May 22, 2015

RE: 72 Bishop Street

The following documentation and supporting information have been prepared in response to staff review comments received on May 12, 2015 and May 13, 2015, responses are in **Italic**.

**BOUNDARY & TOPOGRAPHIC SURVEY**  
 AT  
 72 BISHOP STREET, PORTLAND, MAINE  
 MADE FOR  
**AVESTA HOUSING**  
 307 CUMBERLAND AVENUE, PORTLAND, MAINE

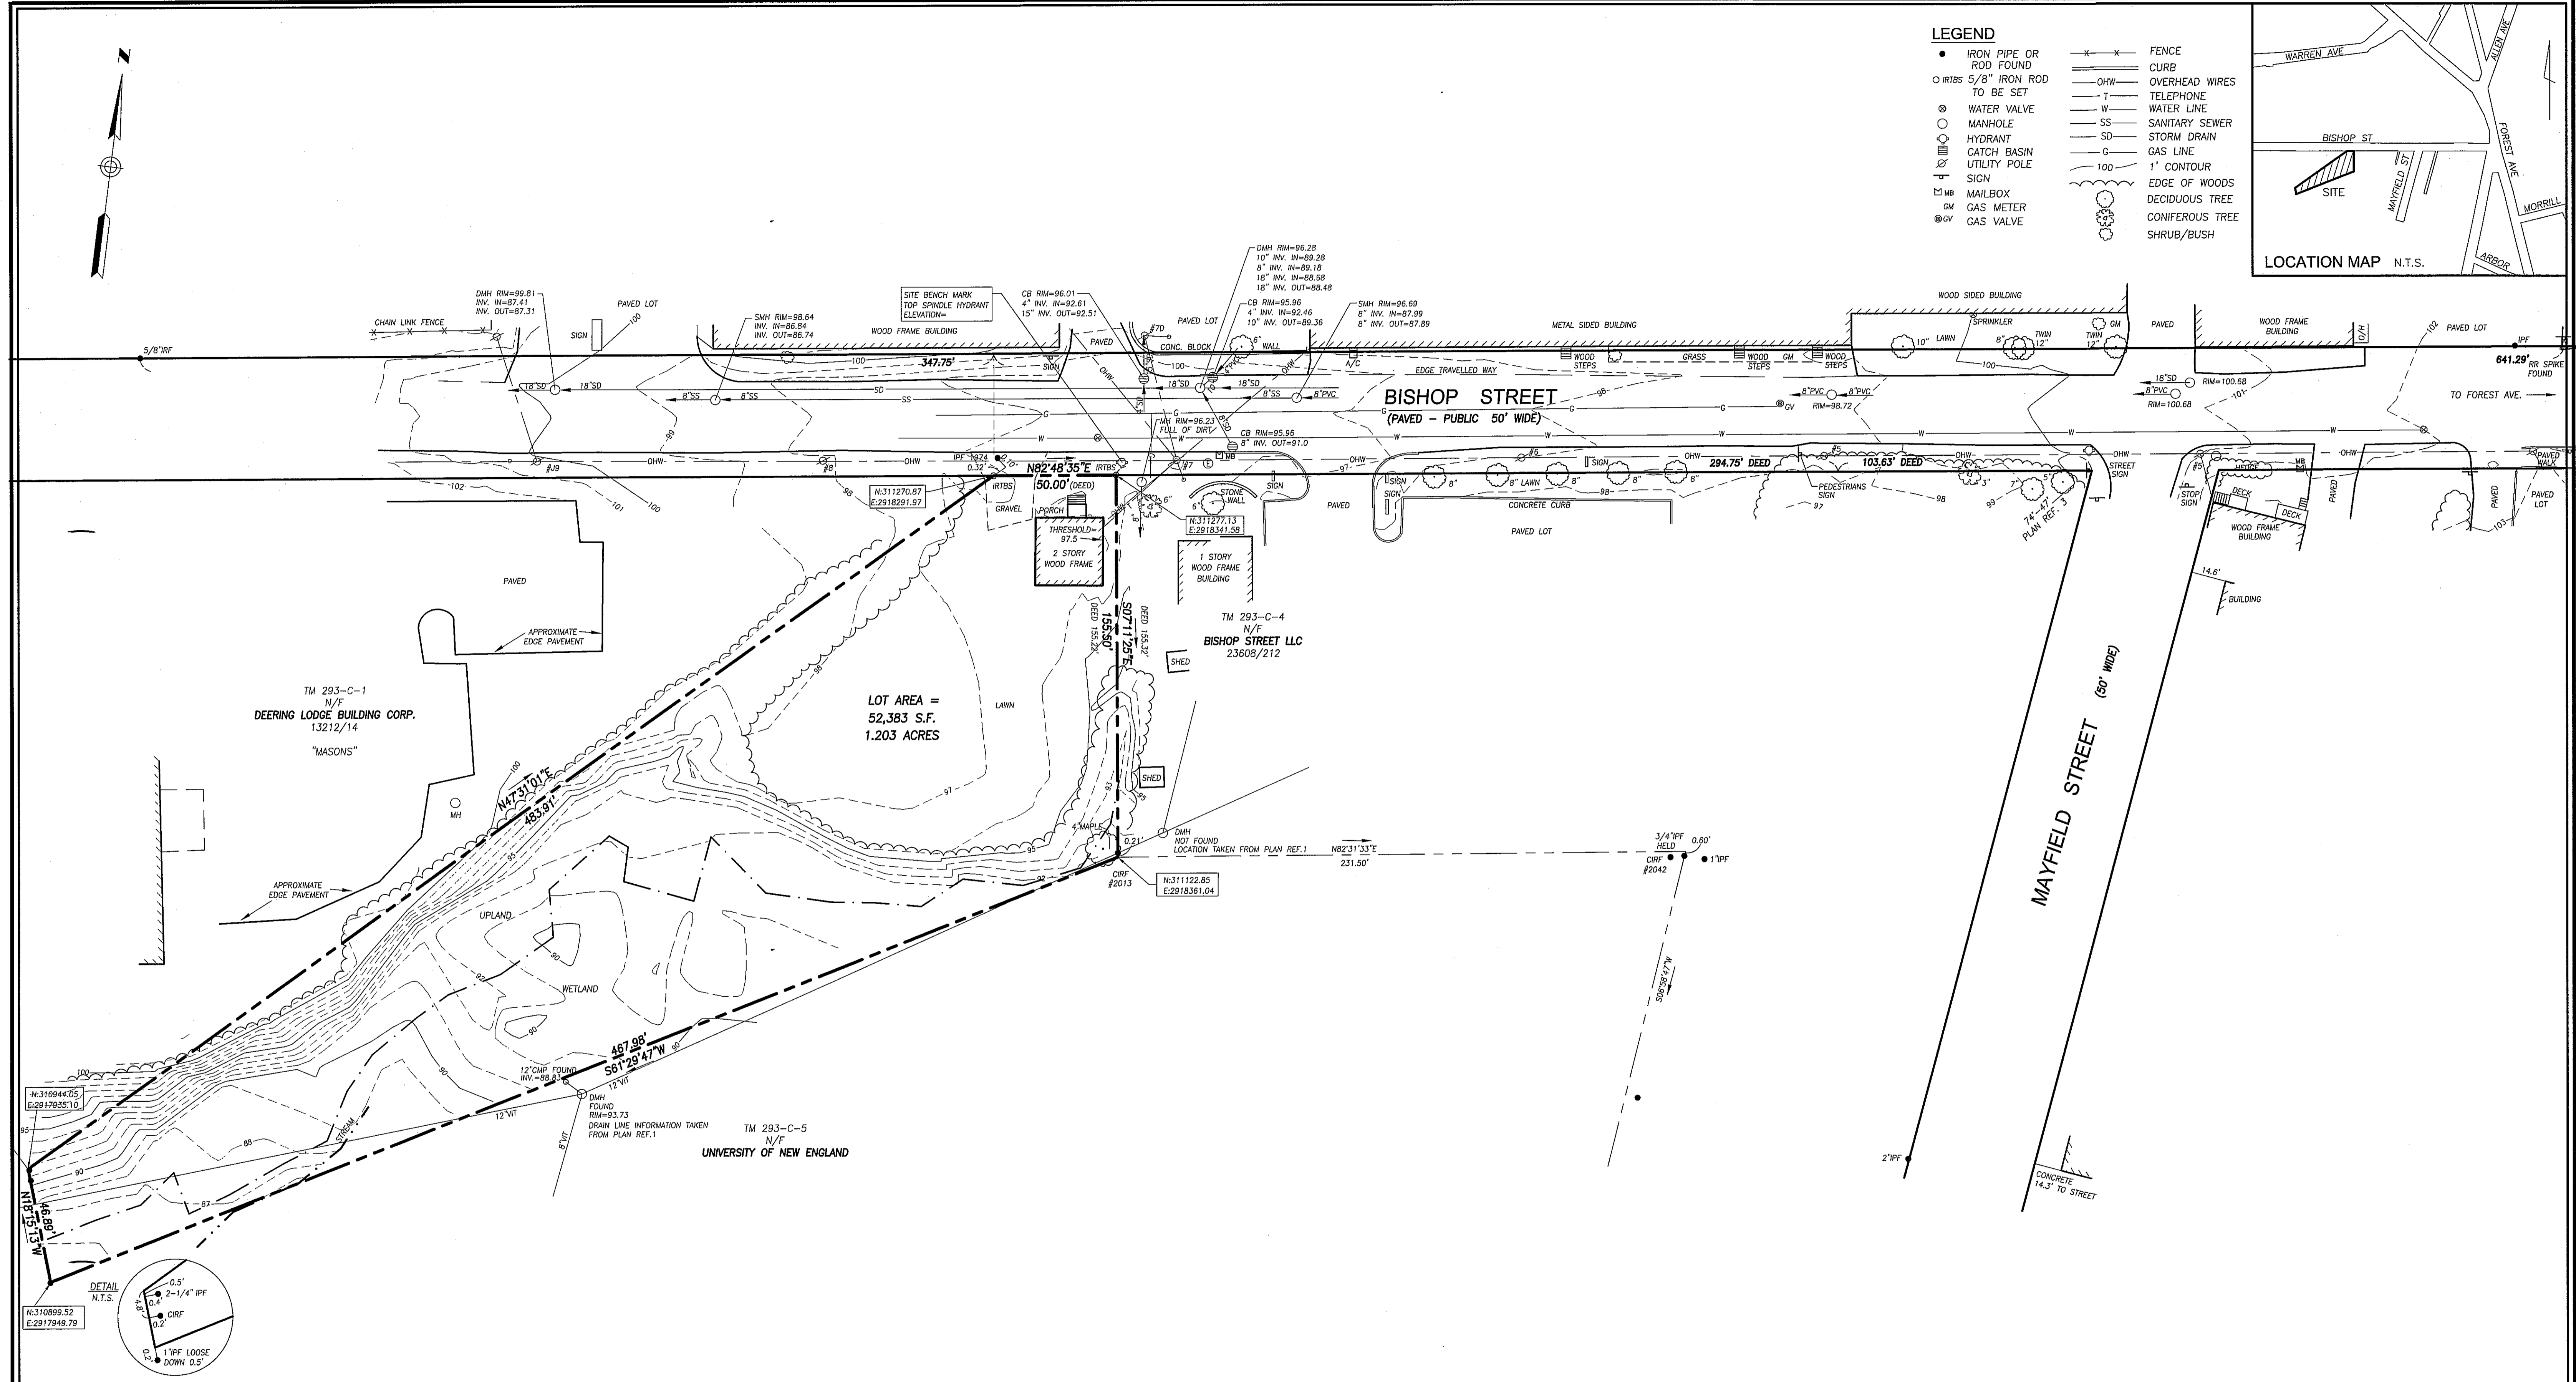
1. Stamped Boundary Survey: Stamped boundary survey is required before the public hearing.

4. An existing stormwater drain is shown crossing the applicant's property. An easement will need to be shown on the survey plan for this utility. For an accurate easement, the cross-country drain manholes will need to be located. If necessary, the City can assist with locating.

3. Survey work is needed to locate the stormwater structures to prepare a 30 foot wide easement for the storm drain. Plans 431/30 and 247/10 in the Engineering Archives show the layout for the storm drain as tied into the lines of Bishop Street and will be helpful in creating the 30 foot wide easement. Drain manholes will need to be located along rim and pipe invert elevations.

4. Site Benchmark: DPS Engineering does not use the top of hydrant spindles as benchmarks. Please use the bonnet bolt over the main hydrant connection.

The survey has been stamped by a Maine licensed professional surveyor and is included in this submission. We received additional comments from William Clark on May 20, 2015 requesting the applicant to confirm the location of an existing City storm water line that crosses the UNE and the proposed development parcel and provide information regarding an easement. We are in the process of scheduling additional survey field work. We are requesting that this information be provided as a condition of approval.

We have coordinated with William Clark who has provided city records for locating the cross-country storm drain and manholes. This information has been provided to Owen Haskell, Inc. to update the plan. This will require additional field survey documentation to the location of buried structure and topographic data.

We received engineering plans from Mr. Clark to assist in locating the storm drain in question. Note: Owen Haskell, Inc. performed a survey for Westbrook College, now UNE in 1974 and the manhole off-site to the easterly side line was located at that time. During field survey for the 72 Bishop Street development, the manhole could not be located, assumed to be buried. Based on the information provided by Mr. Clark, Owen Haskell, Inc. will try narrow down the search area to determine the location of the structure. Rim and invert information may not be available if the structure is substantially buried. Also it is located on an abutters’ property. Updated plans will be submitted upon completion.

The benchmark shall be revised as requested.

Title: LAYOUT AND LIGHTING PLAN

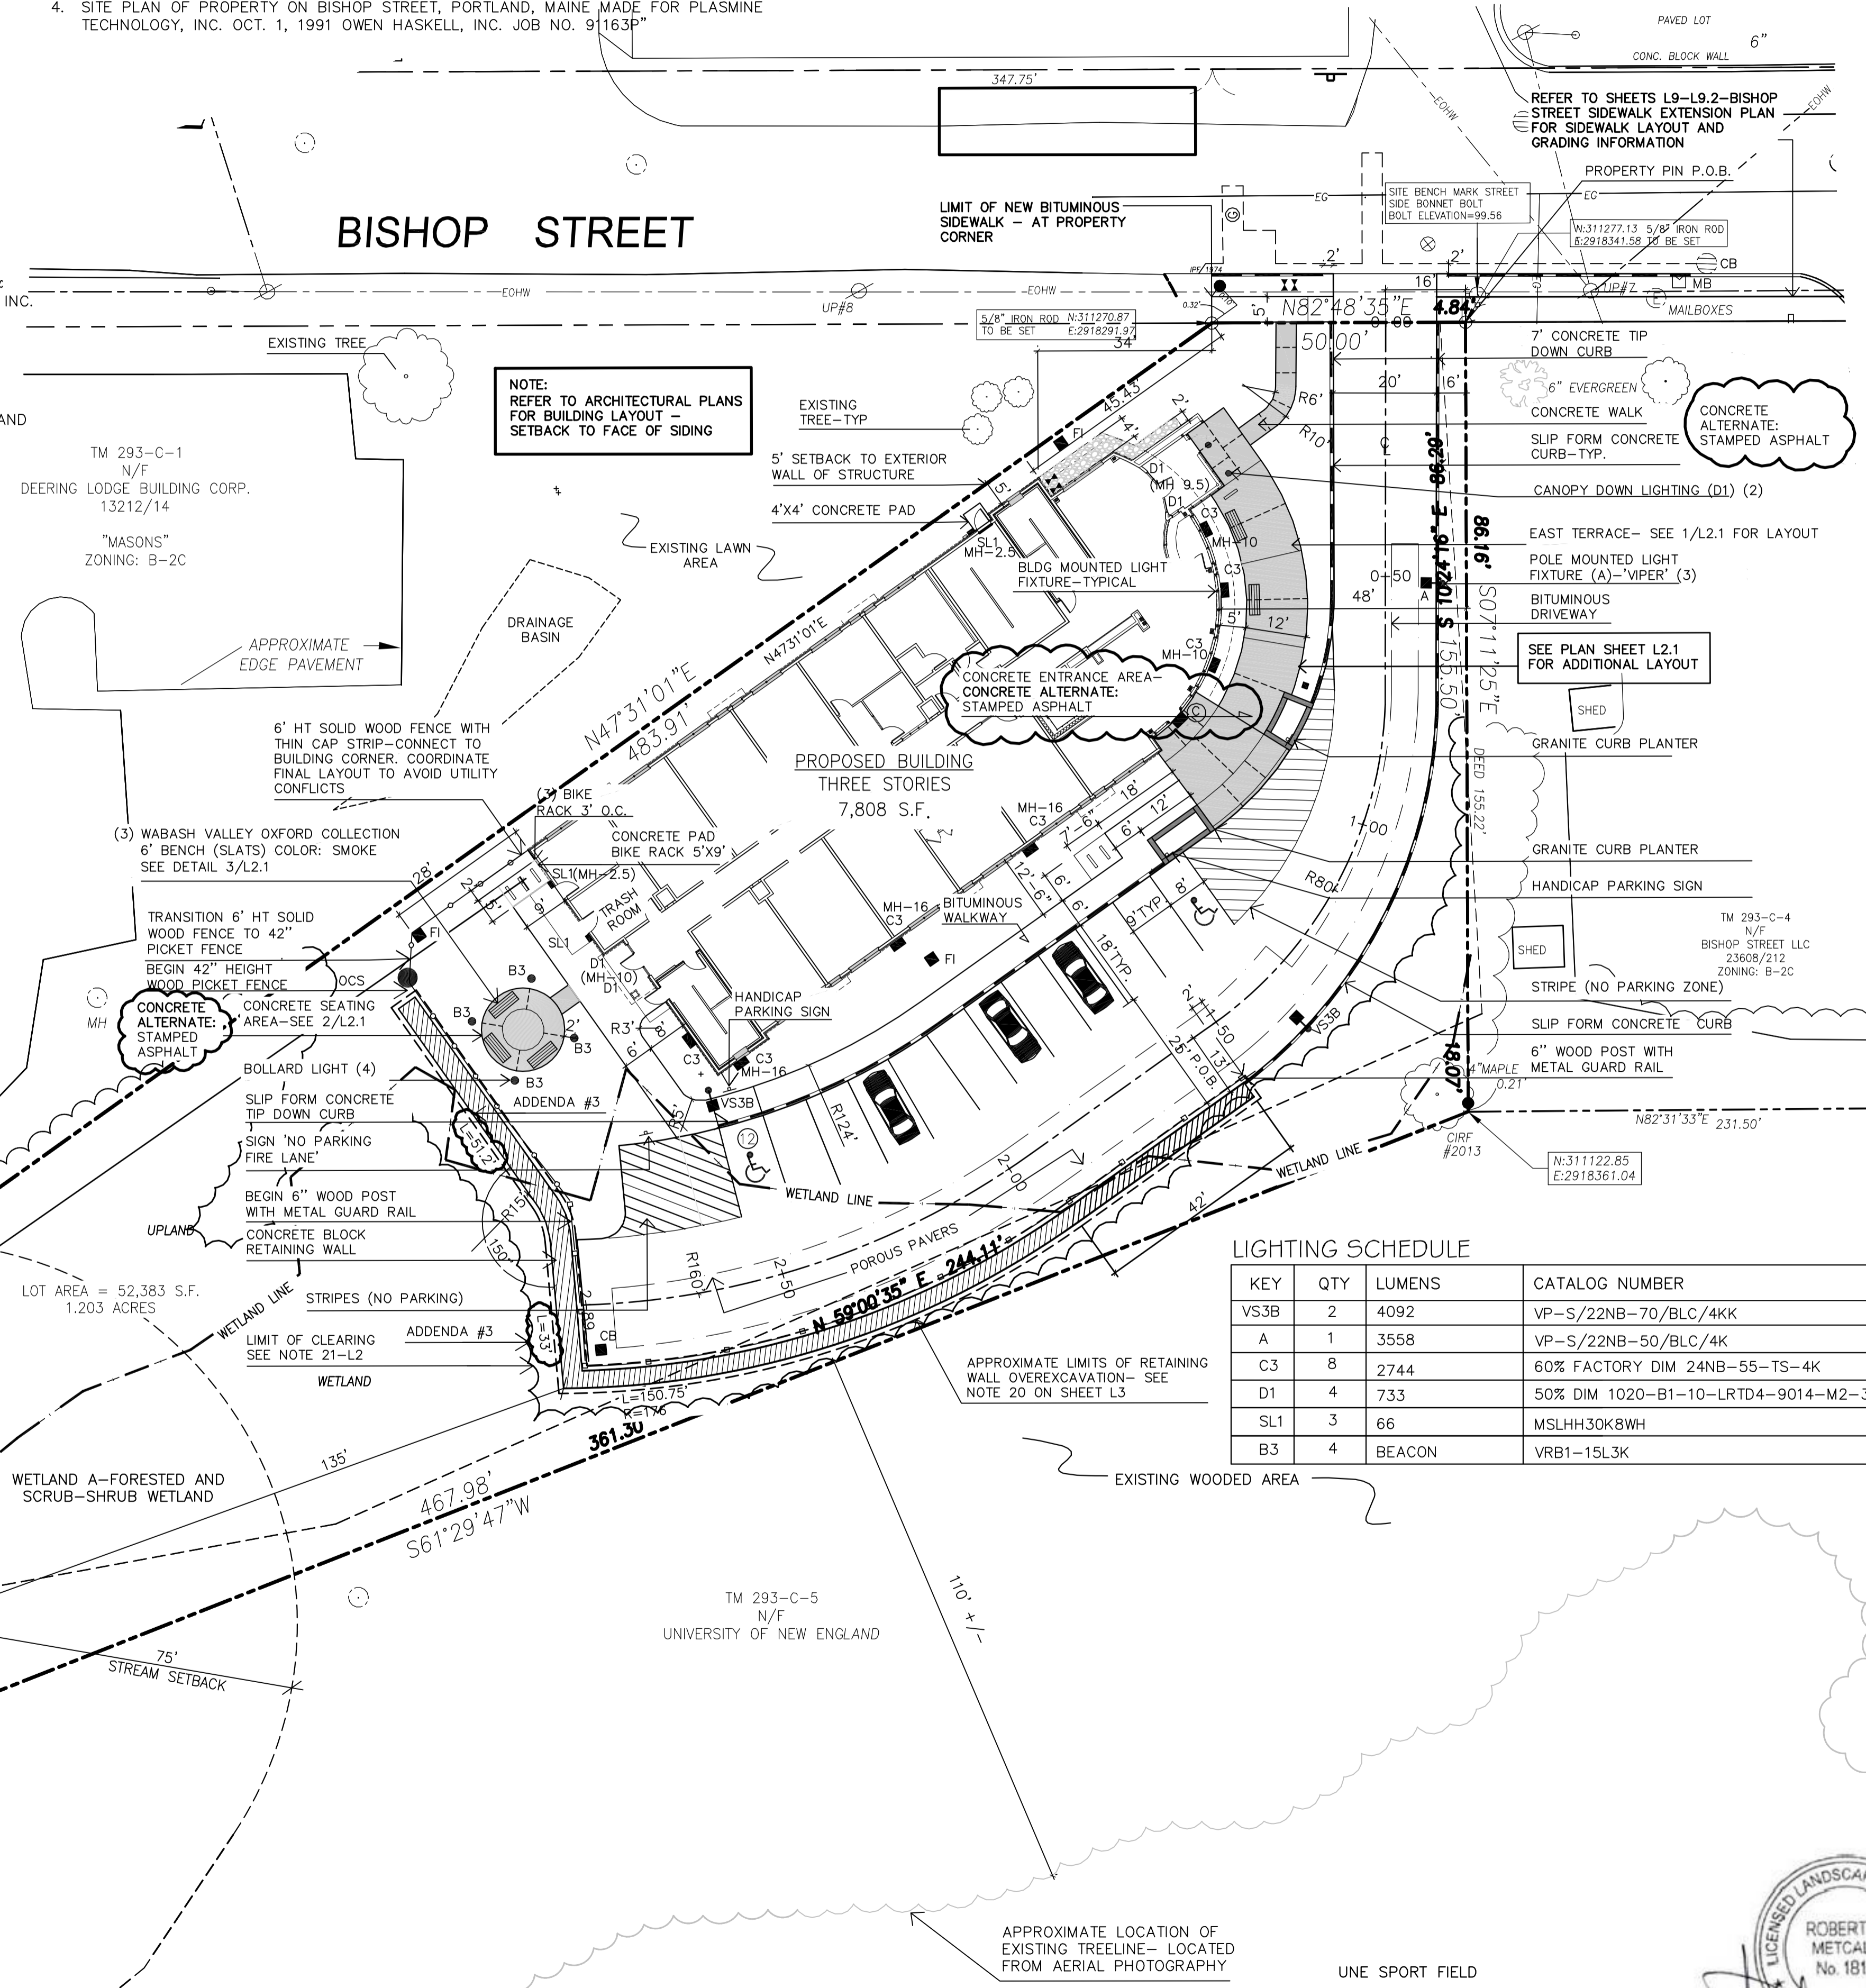
1. Tree & habitat protection measures.

Standard 5: More detail is requested regarding fence heights and material around the property- visual and sound screening is desirable between the parking and neighboring property as well as between the outdoor seating area and neighboring property. What will be the landscape treatment at the northeast face of the building?

Note 22 on the Sheet L2, Layout and Lighting Plan has been added to address Mr. Tarling' comment to assure additional protections to trees and defining the work zone. Note 22 states "PRIOR TO SITE CLEARING, CONTRACTOR SHALL COORDINATE WITH PROJECT LANDSCAPE ARCHITECT TO DEMARCATÉ TREES FOR PROTECTION AND WETLAND AREAS TO BE PROTECTED. EXISTING TREES TO BE PRESERVED SHALL BE PROTECTED DURING CONSTRUCTION AND SHALL BE THE RESPONSIBILITY OF THE GENERAL CONTRACTOR. In addition, this has been added as note 10 on the Planting Plan

As stated on Sheet L2, Site Layout & Lighting Plan, the following fences are shown:

- ***A 6' height solid wood fence was provided along the south west side of building to screen the seating area in the rear of the building.***
- ***A 42'' height wood picket fence along the rear retaining wall between the forested wetland and the landscaped seating area.***

- ***A wood post and guardrail are shown along the top of the retaining wall within the parking lot area. The detail for this is shown on Sheet L6 (Detail 1/L6).***

3 BITUMINOUS SIDEWALK - CITY OF PORTLAND STANDARD  
L5 NOT TO SCALE

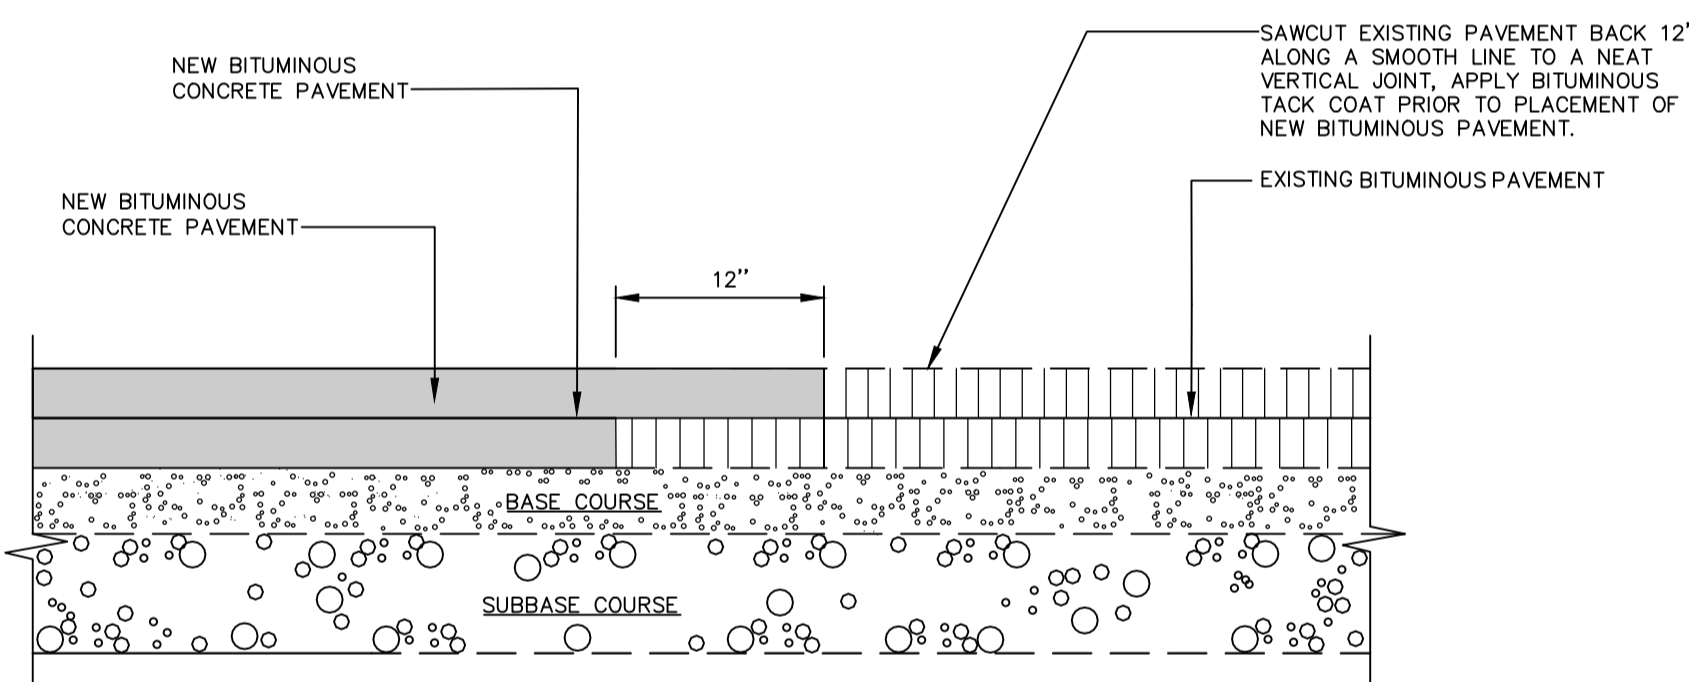
10. Bituminous sidewalk detail.

The bituminous sidewalk detail (Detail 4/L5) has been modified to reflect the City of Portland Standard.

15 SIDEWALK RAMP DETECTABLE WARNING TILE  
L5 NOT TO SCALE

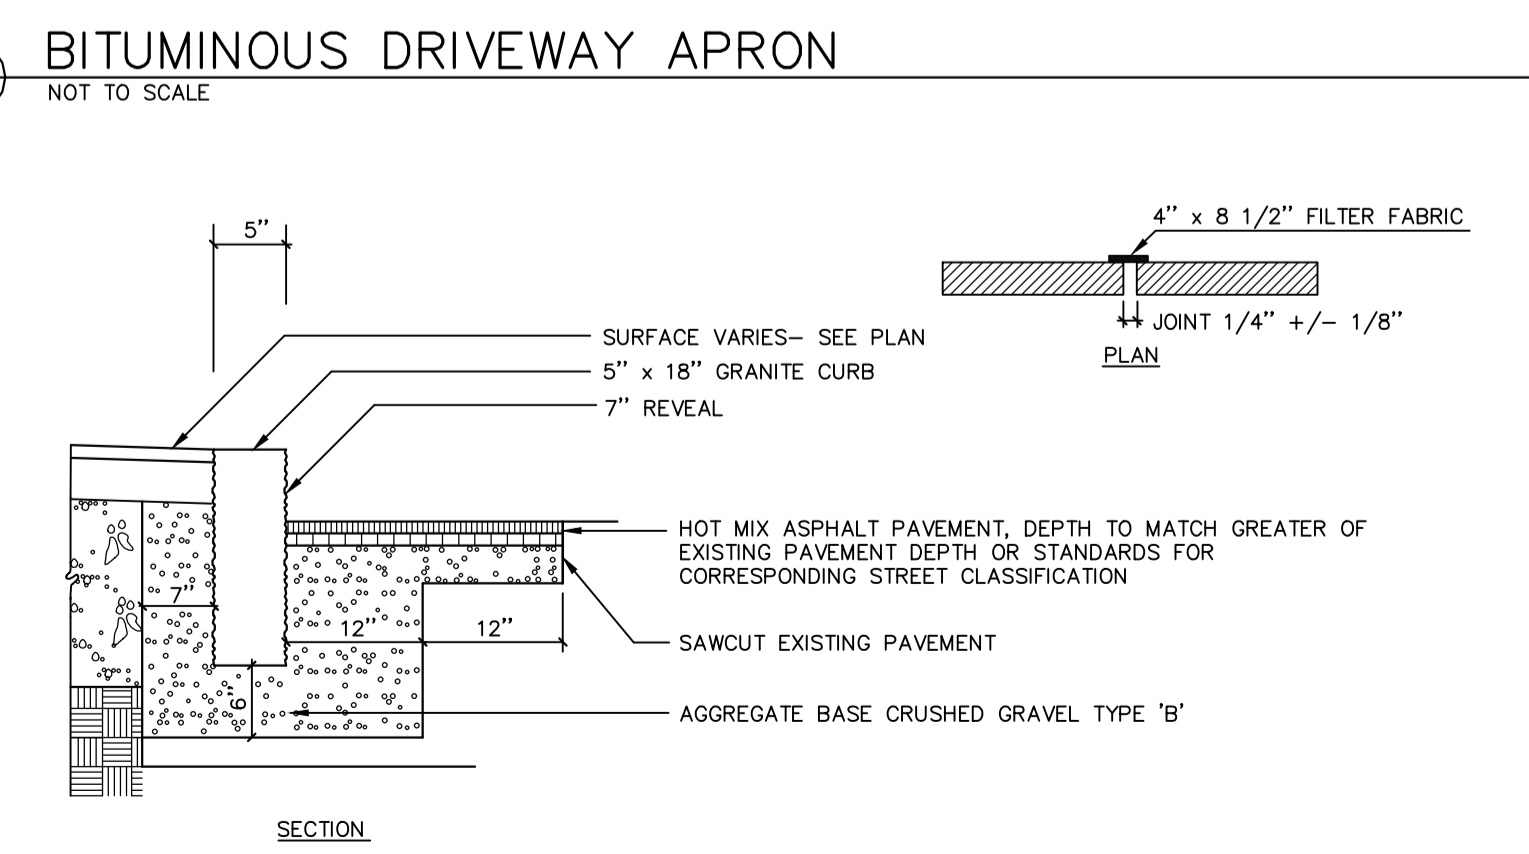
12. Required Details:

- *Detectable Warning Strip (Detail 2/L9 & Detail 15/L5)*
- *Catch Basin (Detail 3/L7)*
- *Storm Drain Trench (Detail 13/L6)*
- *Vegetated Soil Filter (Detail 8/L7)*
